**From:** [Downes, Scott G \(DFW\)](#)  
**To:** [Jeremiah Cromie](#)  
**Cc:** [Torrey, Elizabeth M \(DFW\)](#)  
**Subject:** RE: RU-22-00004 Marlatt - Notice of Application WDFW Comments  
**Date:** Monday, November 28, 2022 9:15:41 AM

**Subject:** RU-22-00004 Marlatt - Notice of Application

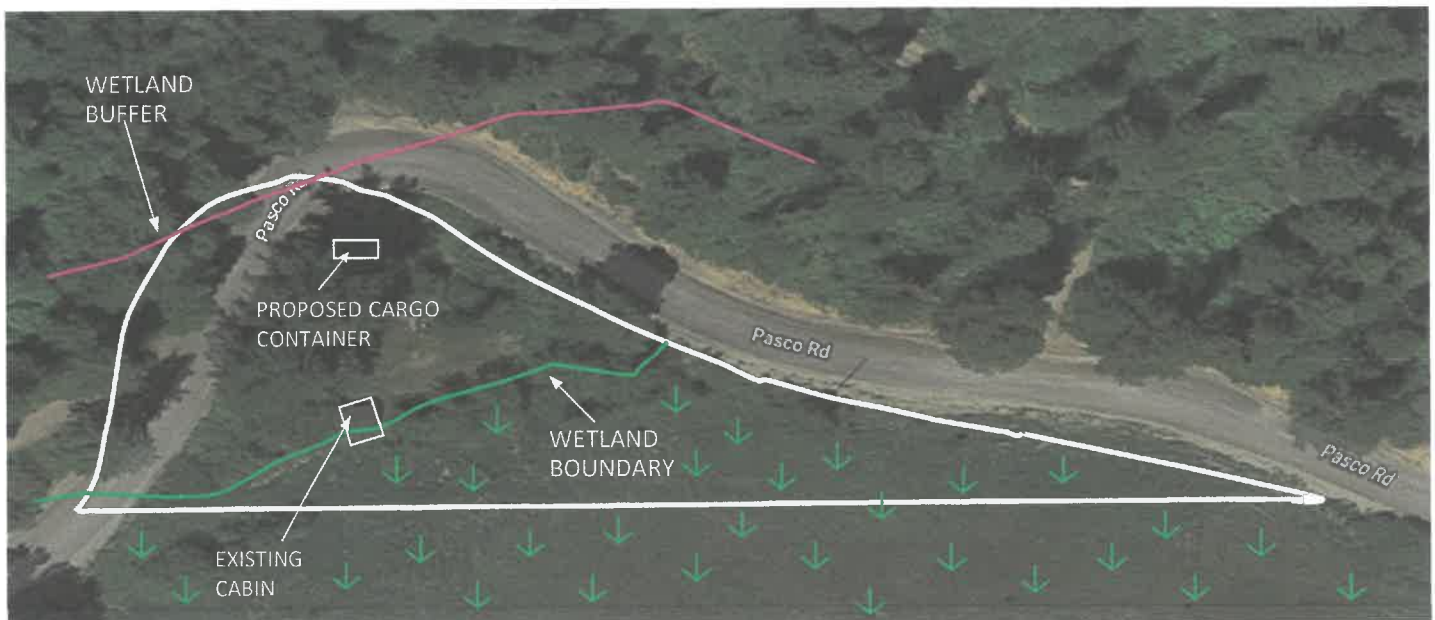
In addition to the wetland and associated buffer, there is a mapped Type N near where the cabin was placed and where the proposed cargo container is to be placed. WDFW would like to have a site visit to assess the stream, its location and the placement of the cargo container and cabin in relation to the stream. The discussion should also include potential mitigation if either are within the riparian zone for the Type N stream.
